**From:** [Brenda Larsen](#)  
**To:** [Jeff Watson](#)  
**Subject:** RE: SG-10-00012 Cle Elum Ridge  
**Date:** Friday, July 30, 2010 4:04:58 PM

After conducting a review of the above named project, I have the following comments:

RECORD OF SURVEY A PORTION OF SECTION 23, TOWNSHIP 20 NORTH, RANGE 15 EAST, W.M. KITITAS COUNTY, WASHINGTON

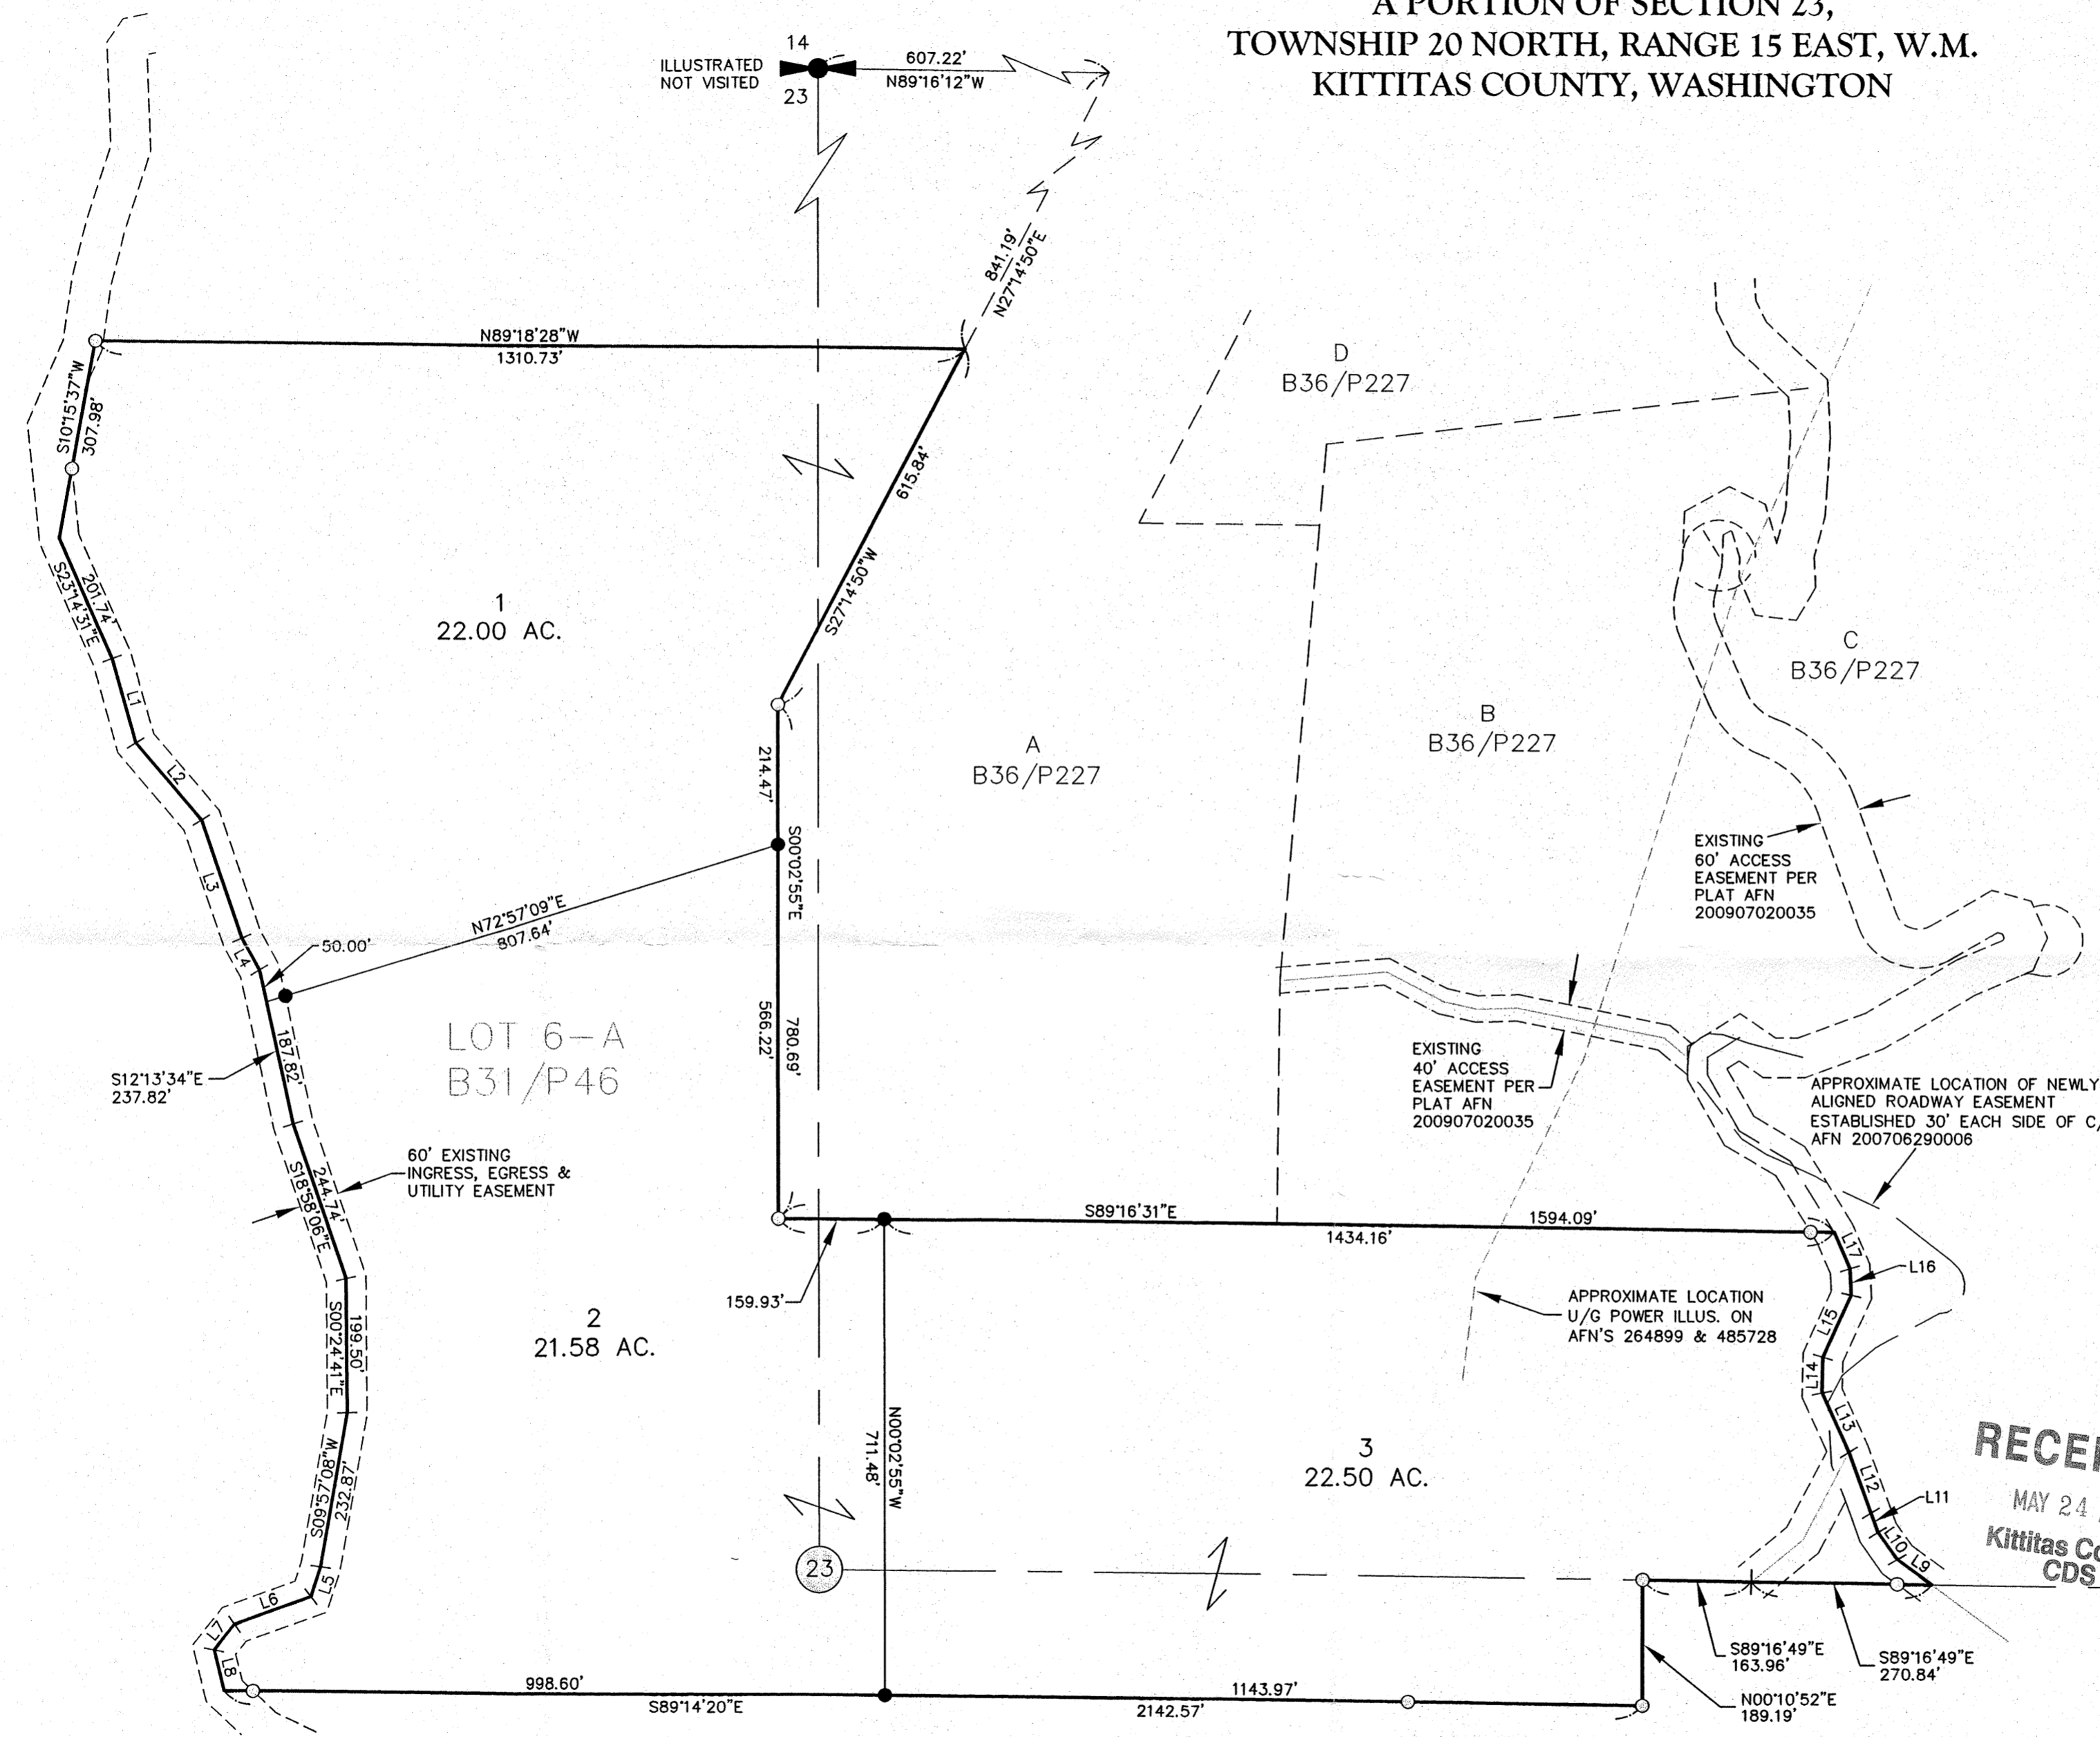
- Ensure that boundary line adjustments do not infringe upon existing structures, to include propane tanks, etc.
- Creation of any additional roads or access must comply with the International Fire Code.
- All future development must comply with the International Fire Code.
